CITY OF ALBUQUERQUE  
PLANNING DEPARTMENT  
DEVELOPMENT REVIEW BOARD

**Project# 1007871**

**14DRB-70066 EXT OF MAJOR PRELIMINARY PLAT**

MYERS, OLIVER & PRICE agent(s) for BISHOP'S COMPOUND, LLC request(s) the above action(s) for all or a portion of Lot(s) 2 & 3, **ALVARADO GARDENS (TBKA BISHOP'S COMPOUND SUBDIVISION)** zoned R-LT, located on CANDELARIA RD NW BETWEEN CALLE SAN YSIDRO, NW AND RIO GRANDE BLVD, NW containing approximately 1.3379 acre(s). (G-12)

# PRELIMINARY PLAT OF BISHOP'S COMPOUND SUBDIVISION

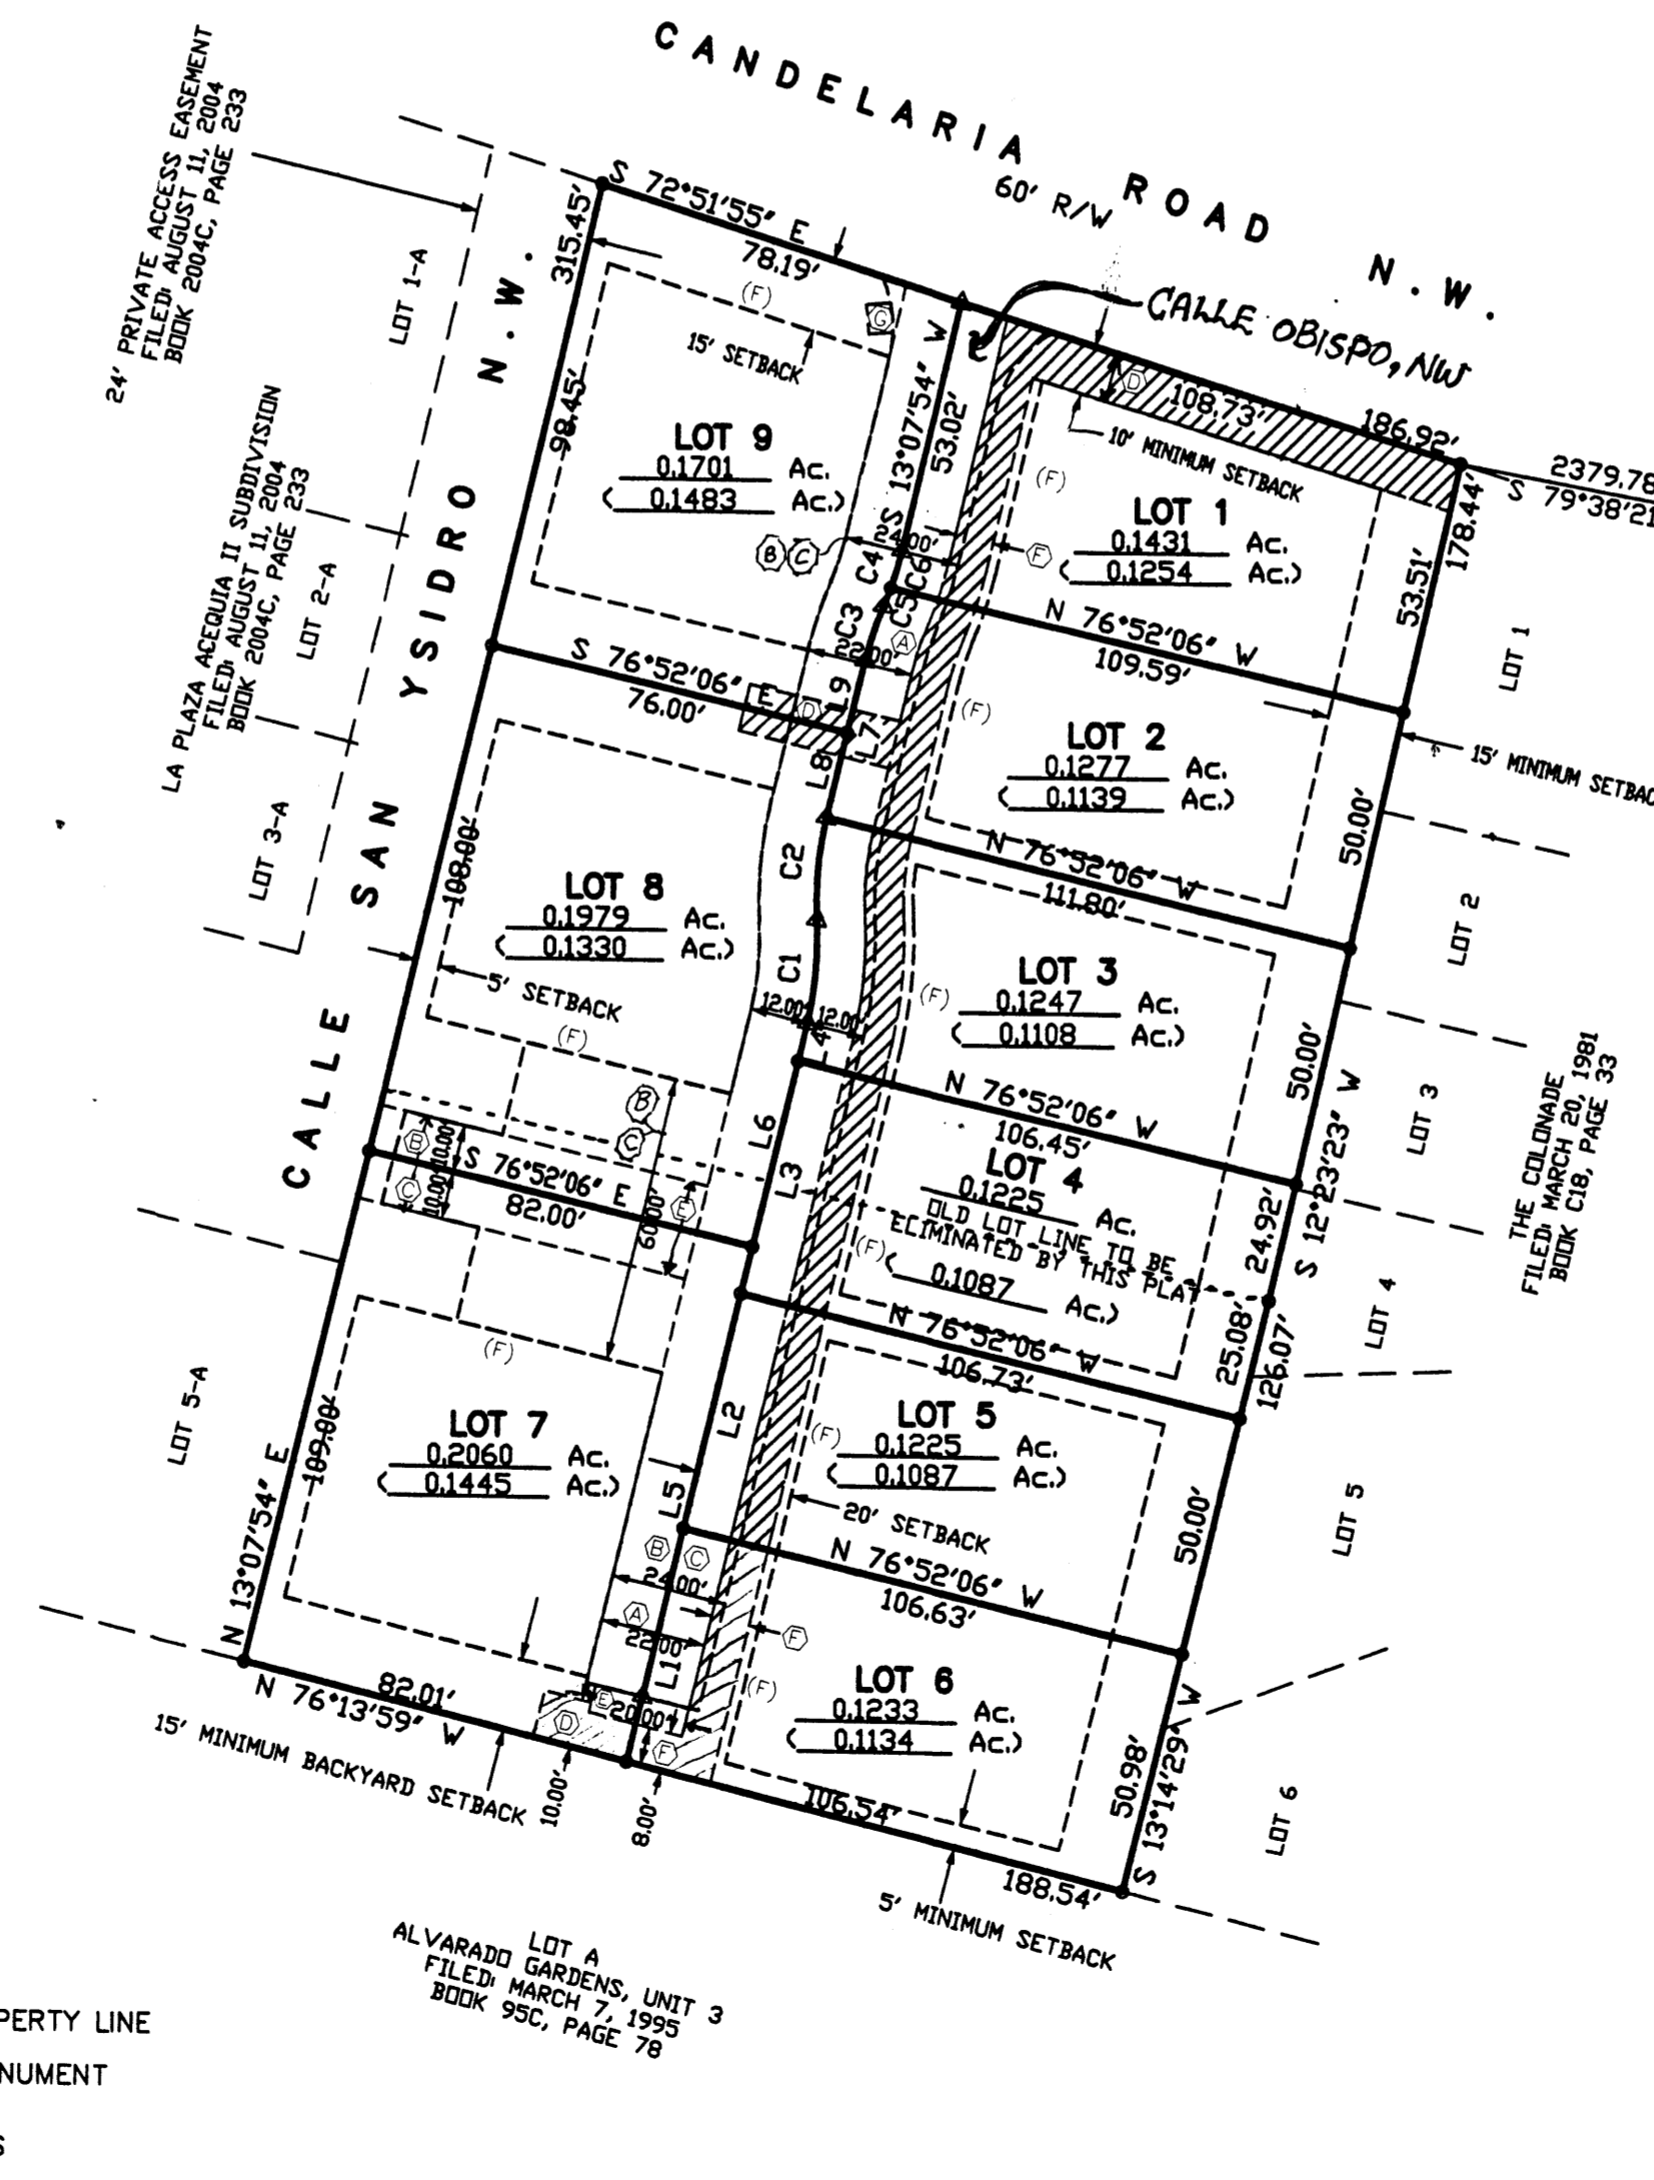
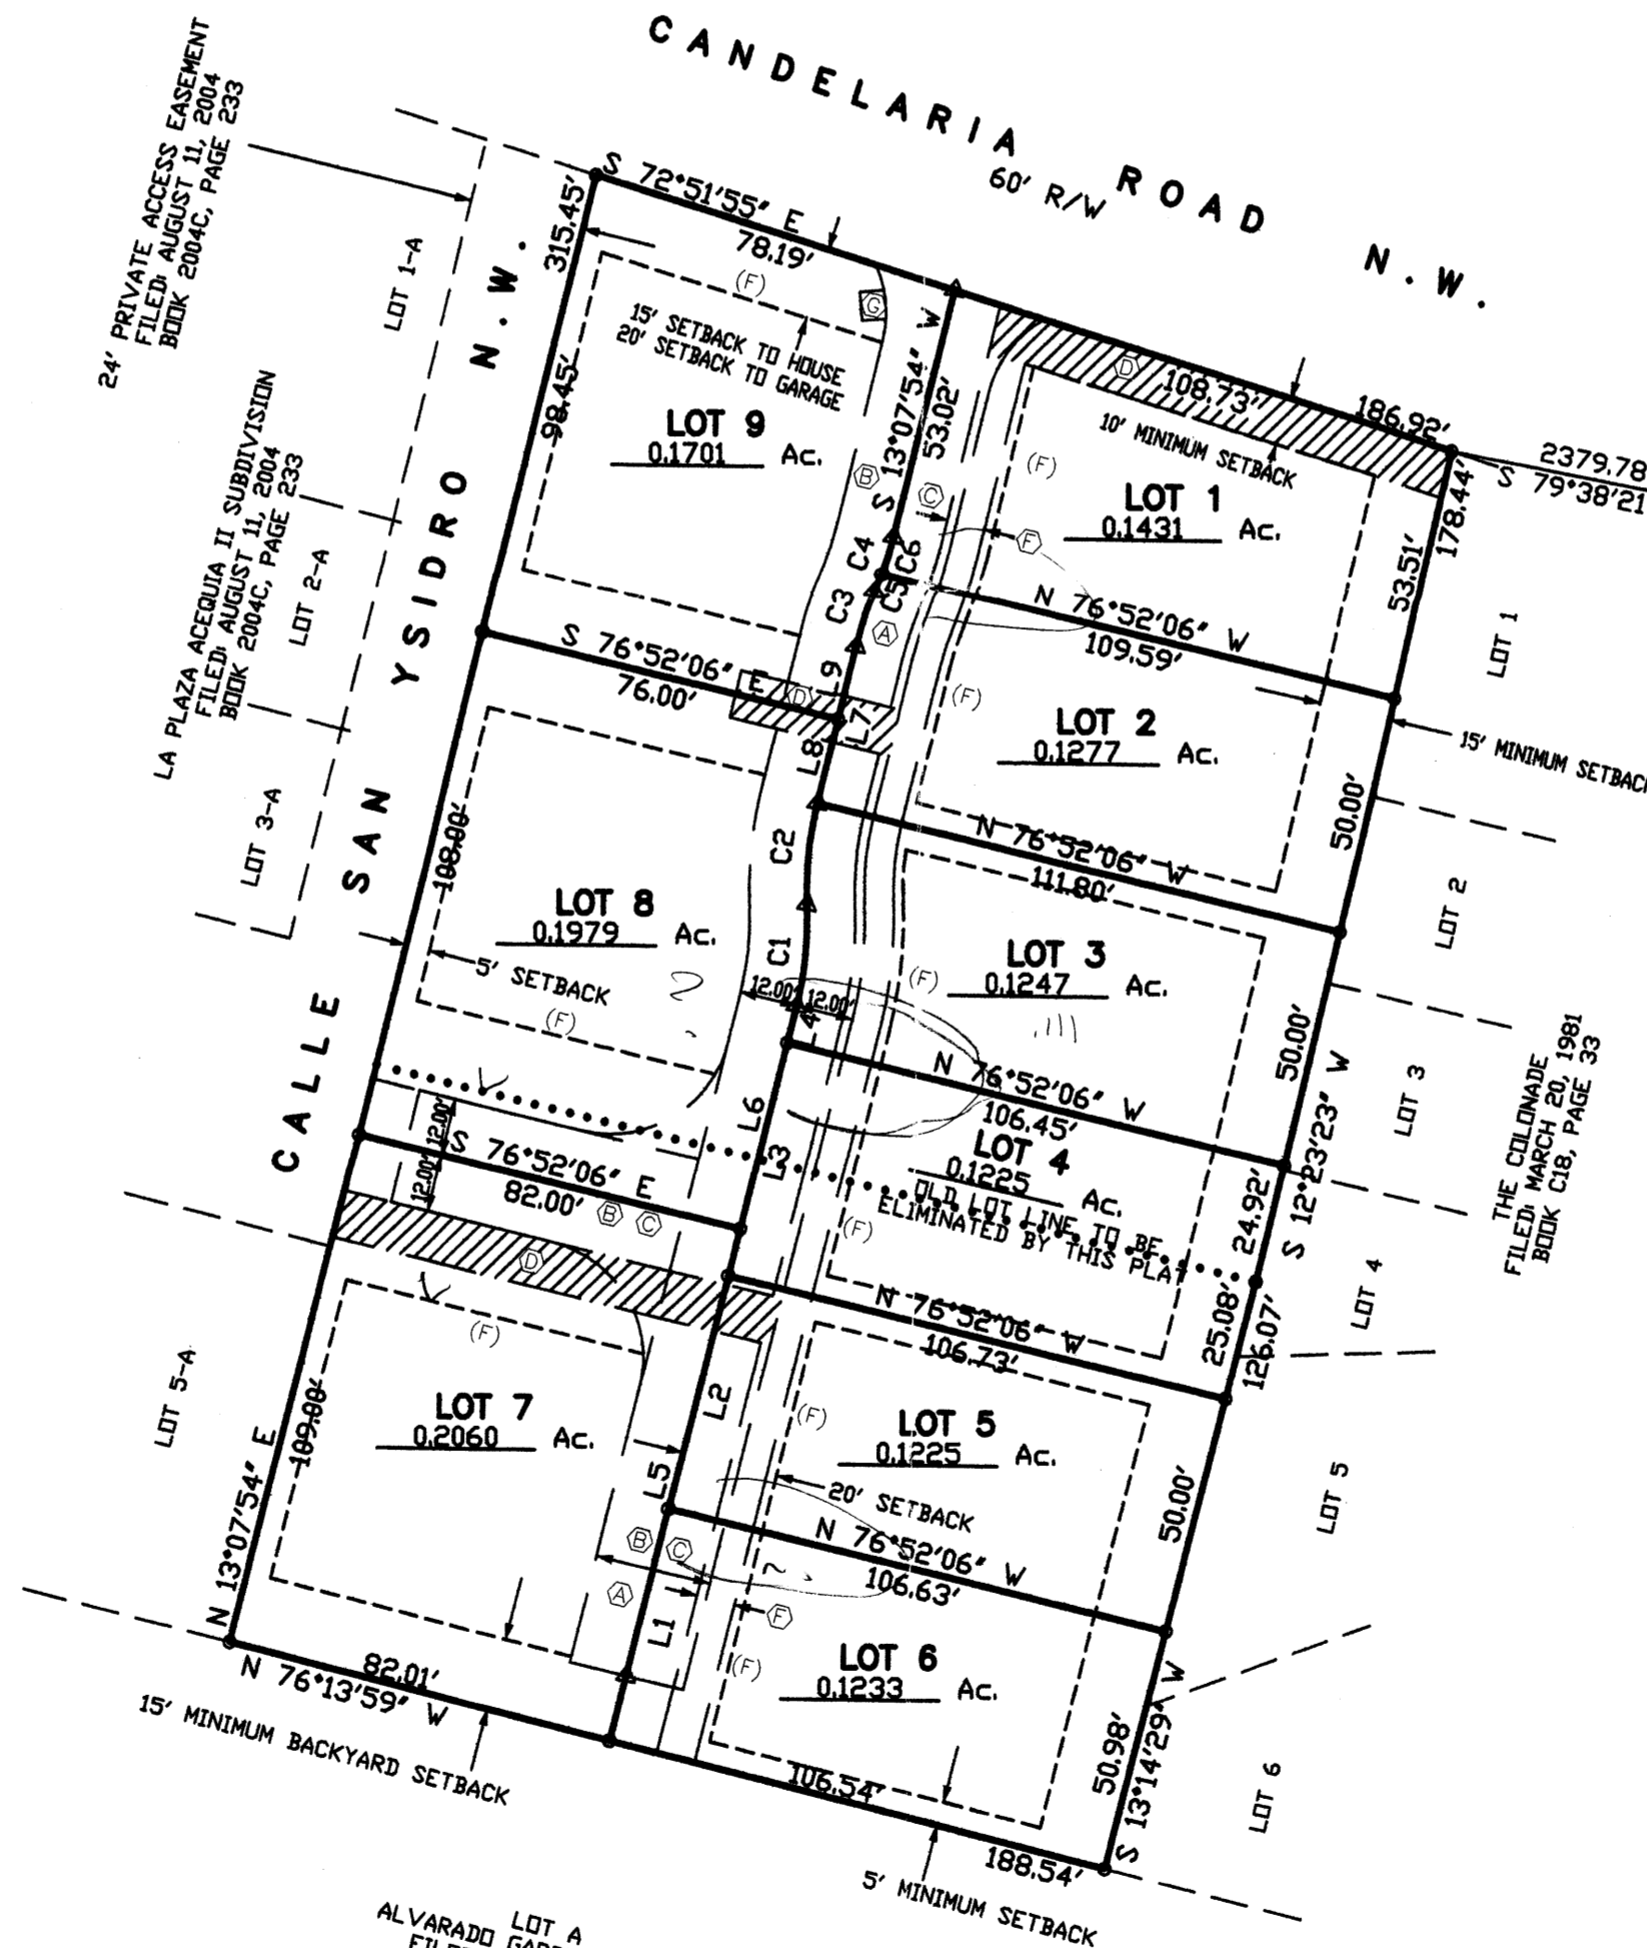
The design variance request is incomplete. Based on the information provided, variances would be required for roadway materials, turnaround design, and street width. Appropriate justification must be included for each request.

Provide an exhibit showing the location of sidewalk and defining the distance from face of curb to the property line. Right of way dedication may be required.

Clarify the width and location of the private access easement (defined in keyed note B). Define the beneficiaries of the proposed easement.

An appropriate turnaround (per City of Albuquerque Standard Specifications) must be provided.

The turnaround shown on the plat would require a design variance. Provide an exhibit demonstrating adequate turning radii is provided with this turnaround. Written approval from the Refuse Division and Fire Marshal is also required.

Additional information must be provided regarding lot 9 accessing Rio Grande Blvd. Please note that any curb cut for lot 9 must be at least 25 feet from the point of intersection of the two curblines extended. See Chapter 23, Section 6, Part A of the *Development Process Manual*.

No Easement "E" shown on plat. Defer sidewalk and roadway waiver to transportation.

The exclusion of proposed Lot 9 from the proposed access easement does not provide for coordinated land development or convenient circulation in accordance with the Subdivision Ordinance. La Plaza Acequia and others have not had lots with direct access to Candelaria.

Setbacks need to be noted on the plat for each lot (incl. 20 ft min setback from garage doors) - the submitted 'Typical Lot Layout' does not provide a minimum 10 ft sideyard setback along the east side of proposed Lots 7 - 9 along Calle Obispo NW, nor does it provide a minimum 15 ft frontyard setback for proposed Lots 1 - 6.

Net Lot Area (gross lot area minus access easement area) needs to be noted on the plat for each lot.

Easements B., C., and D. need to be dimensioned; Easement E. is not located.
